From: tom gibbs [REDACTED]
Sent: 20 July 2022 09:38
To: Amber Willard
Subject: RE: bn/69/22/hh
Attachments: British Larch Example.jpg

I am the officer on your application at BN/69/22/HH at Critchmere Road.

PROJECT	SUITABILITY	DATE
15 Critchmere Road	Planning	03.2020
Eastergate	SCALE	
	1:100@A3	
DRAWING TITLE	DRAWING NUMBER	REVISION
Proposed Elevations	PL-04

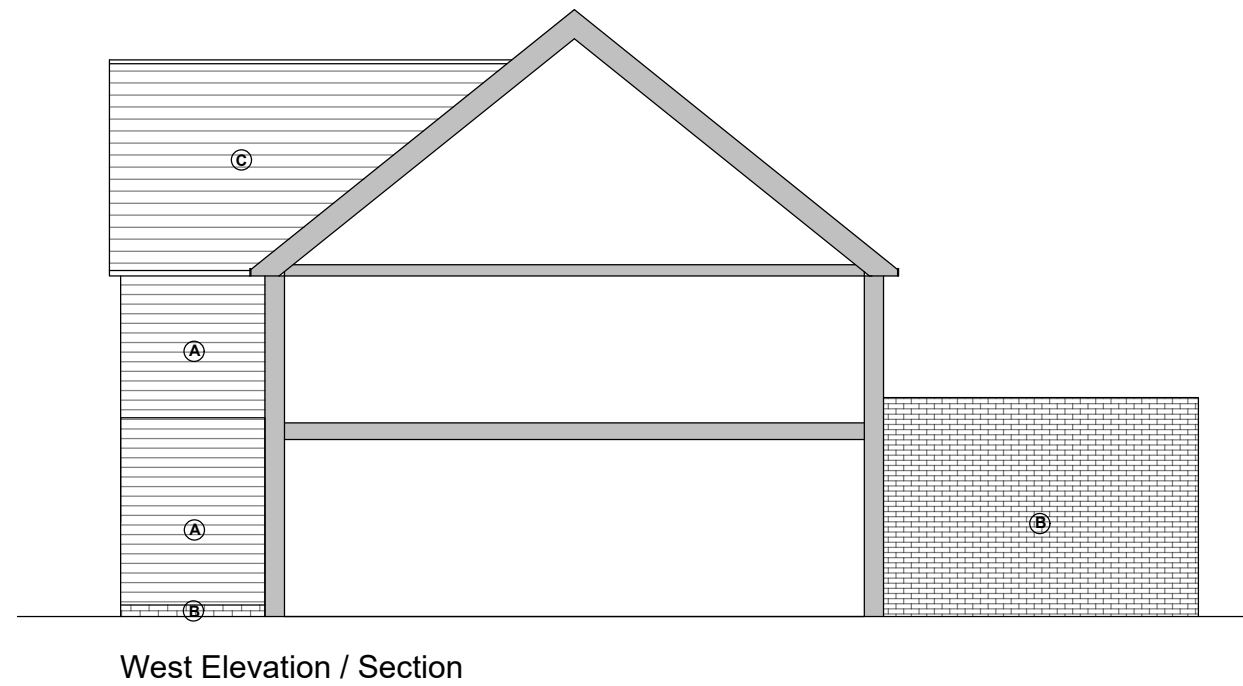
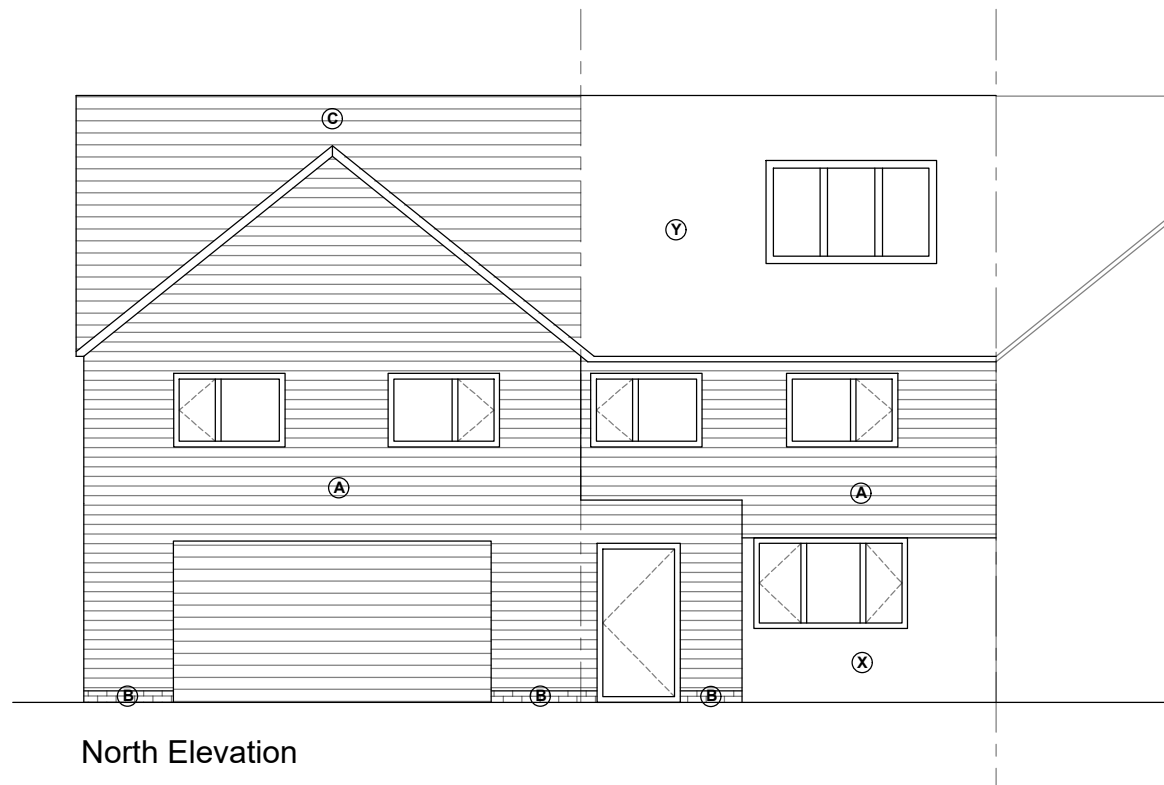
I am just writing to check the type of cladding proposed. I note the previous application stated larch wood, but this just says timber.
Will it be the same.

If you happen to have a photo of the cladding to be used that will be helpful.

The intention is to use British Larch - If there is any issue with this, please do let me know.

Please see attached photo for reference.
